Re: Development Application D/2017/349 (SSD 8105)

My objections to this DA, as presented, are based on items from the Secretaries Environmental Assessment Requirements (SEAR) which are discussed below.

REDUCTION CALCULATION METHOD 2
WITHOUT CONTEXT

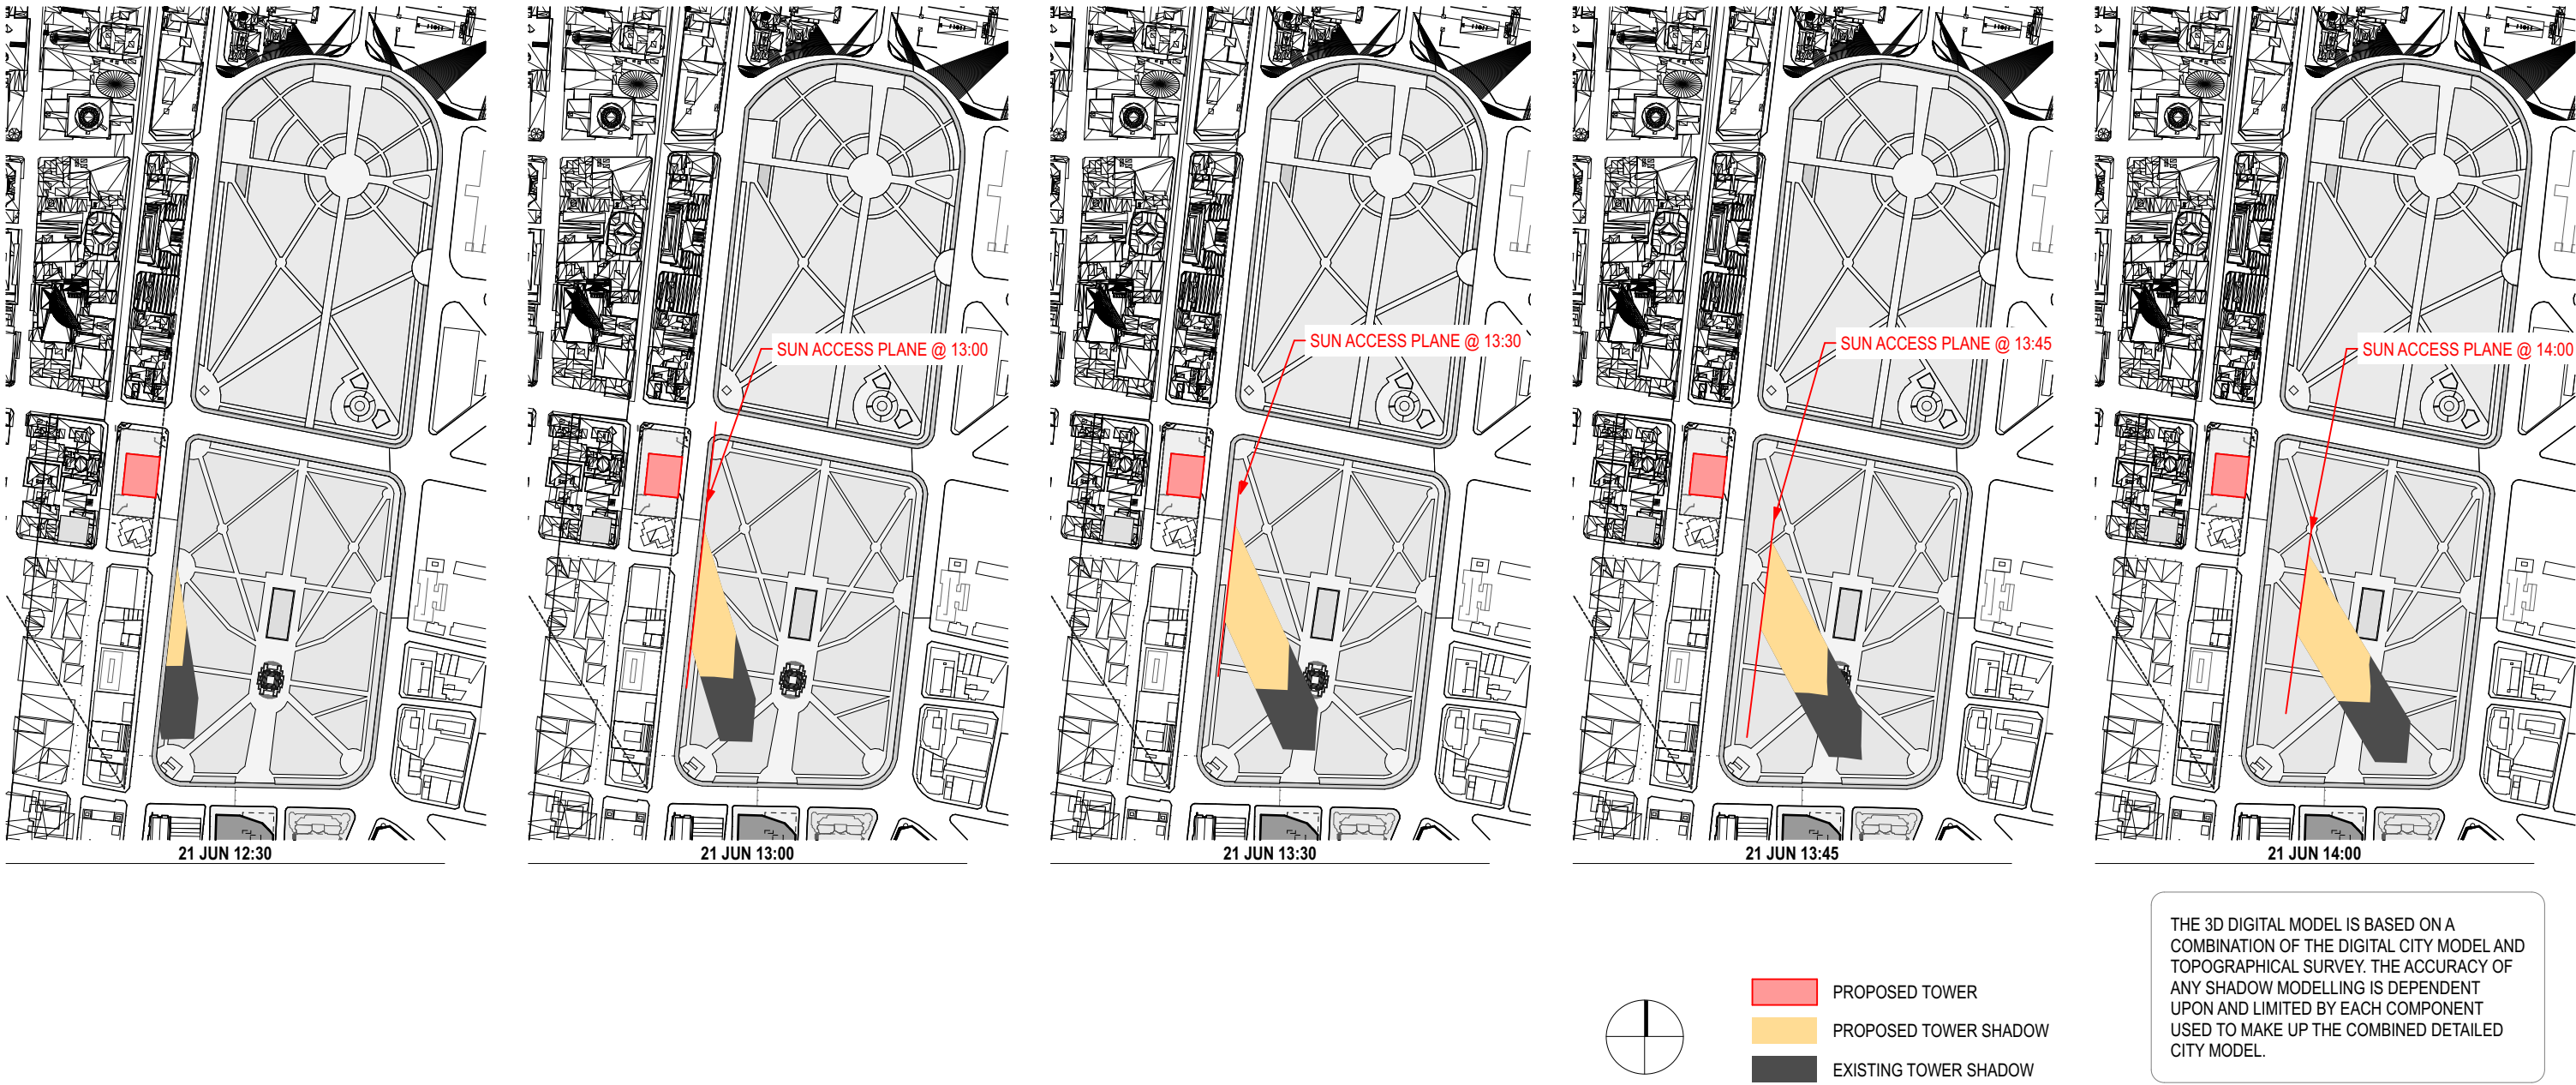
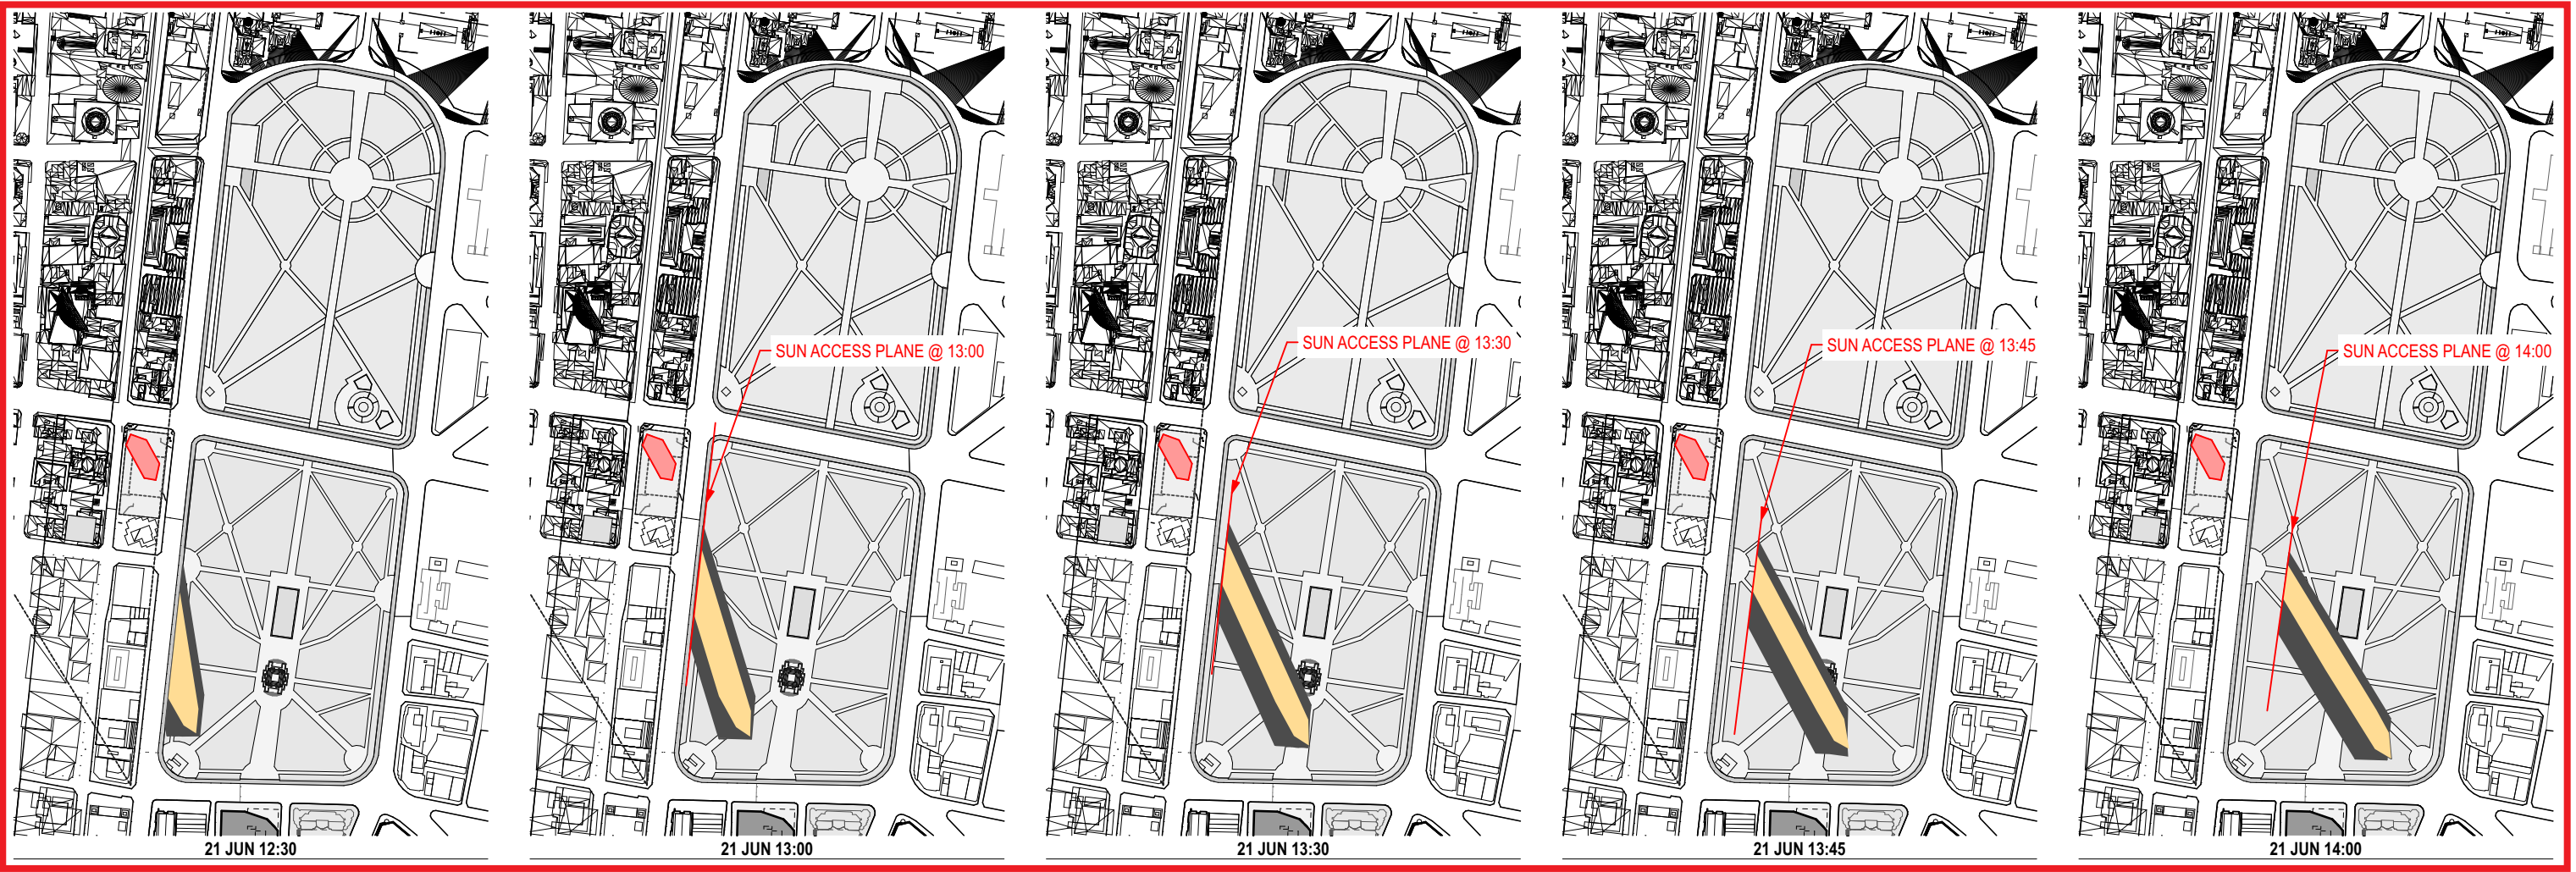
The figures on the reduction in overshadowing of 50% is excellent but keep the impact in perspective. The actual total reduction on the ground in Hyde Park is less than 2%. Also, there is no account taken of the overshadowing of Hyde Park by the fourteen level podium structure.

Setbacks | Sydney DCP

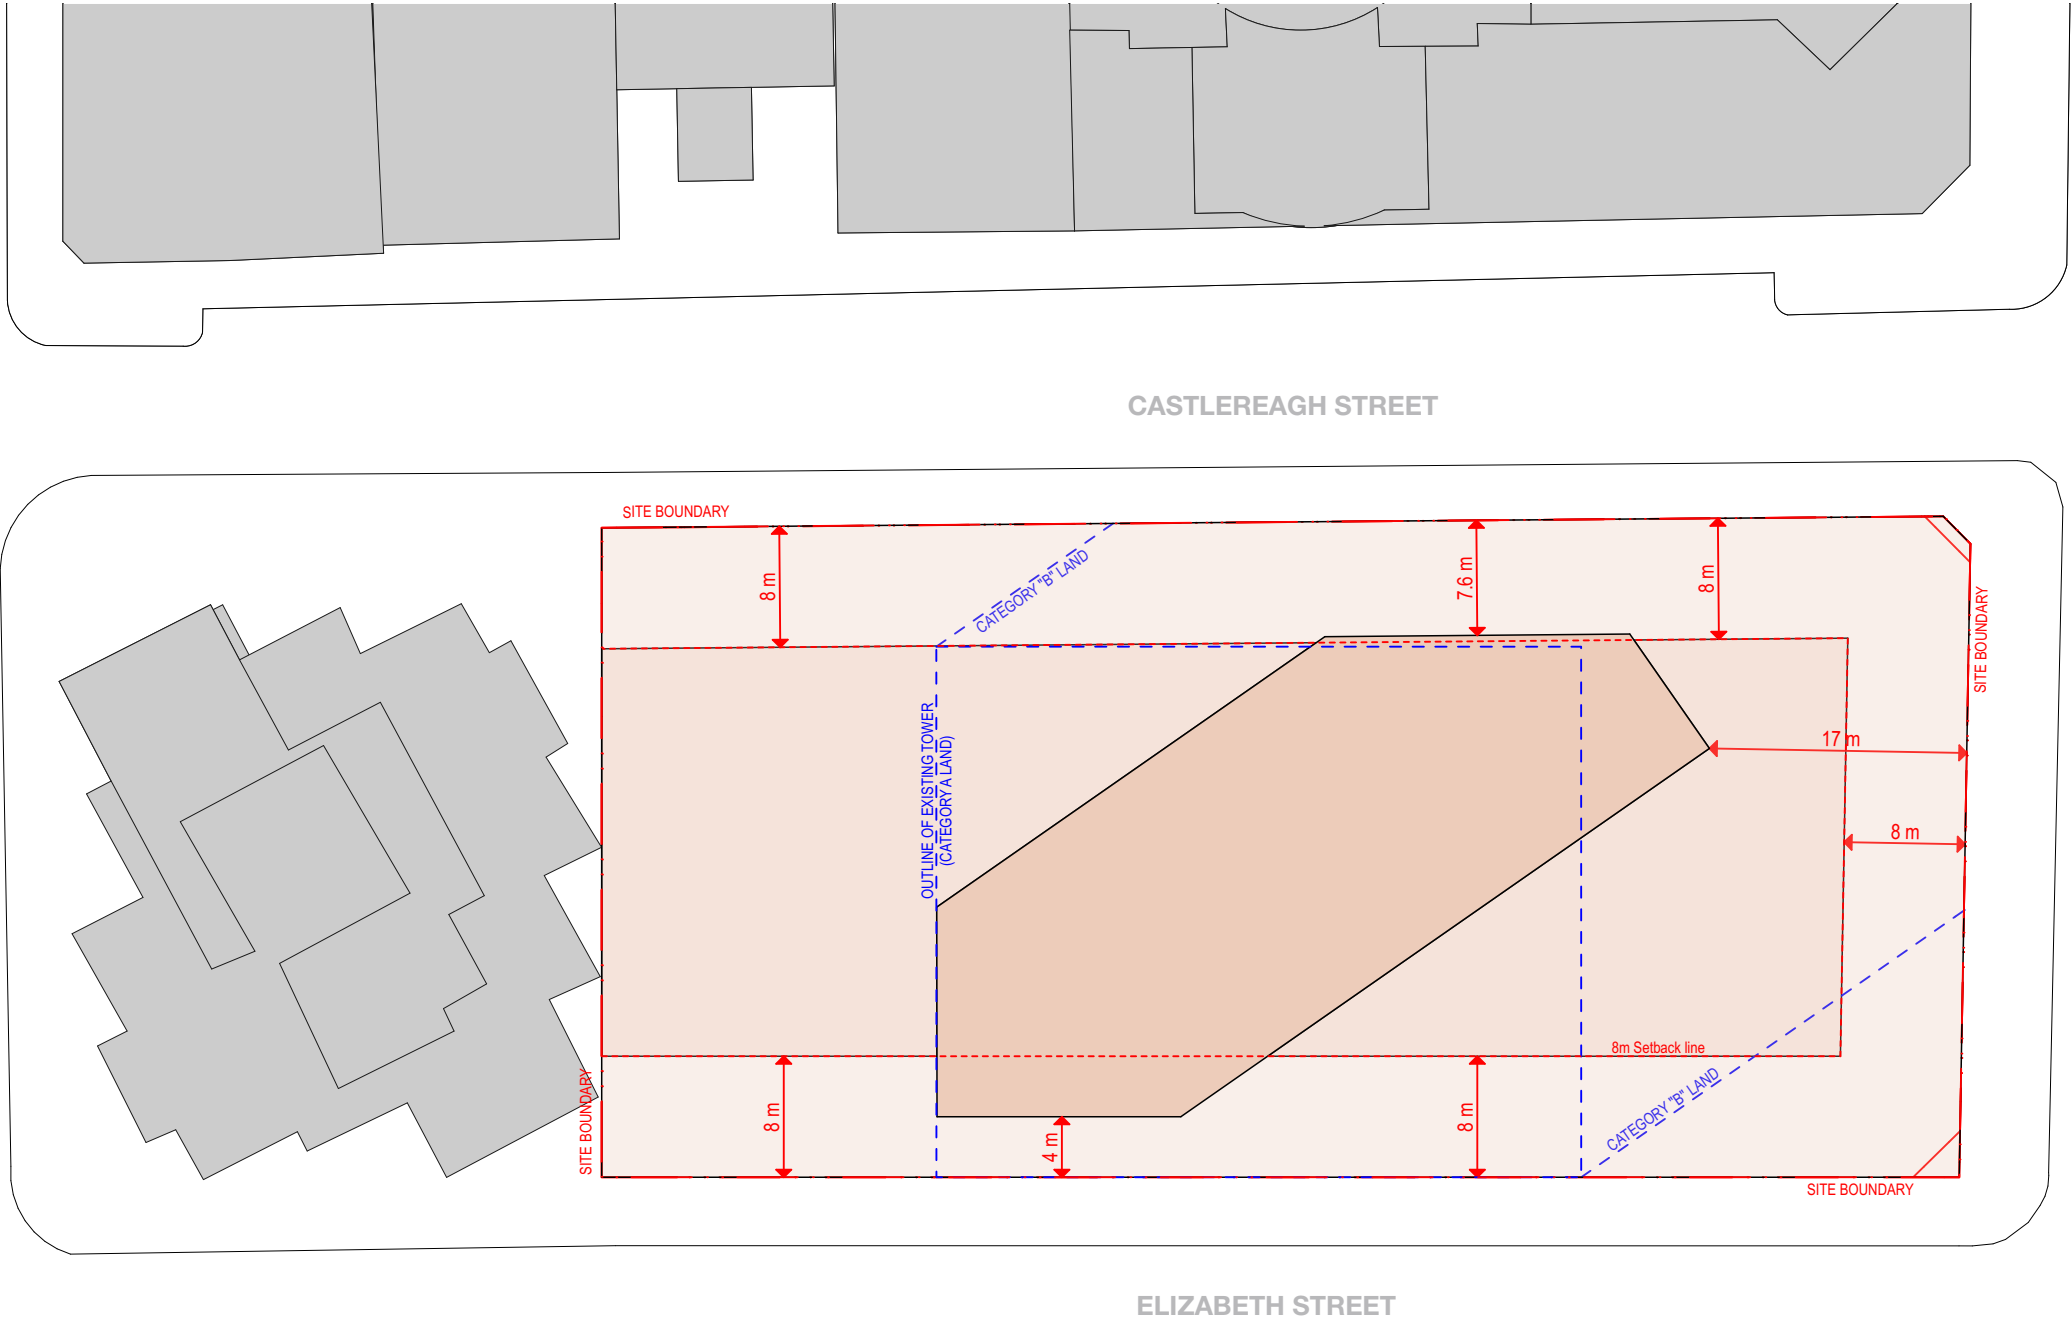
- Is the development 50, 51 or 52 levels high?
- Is the podium twelve or fourteen levels?
- Is the tower setback five or eight metres?
- Is the pedestrian link to Museum Railway Station a “potential”, “future” or “proposed” inclusion in the design?
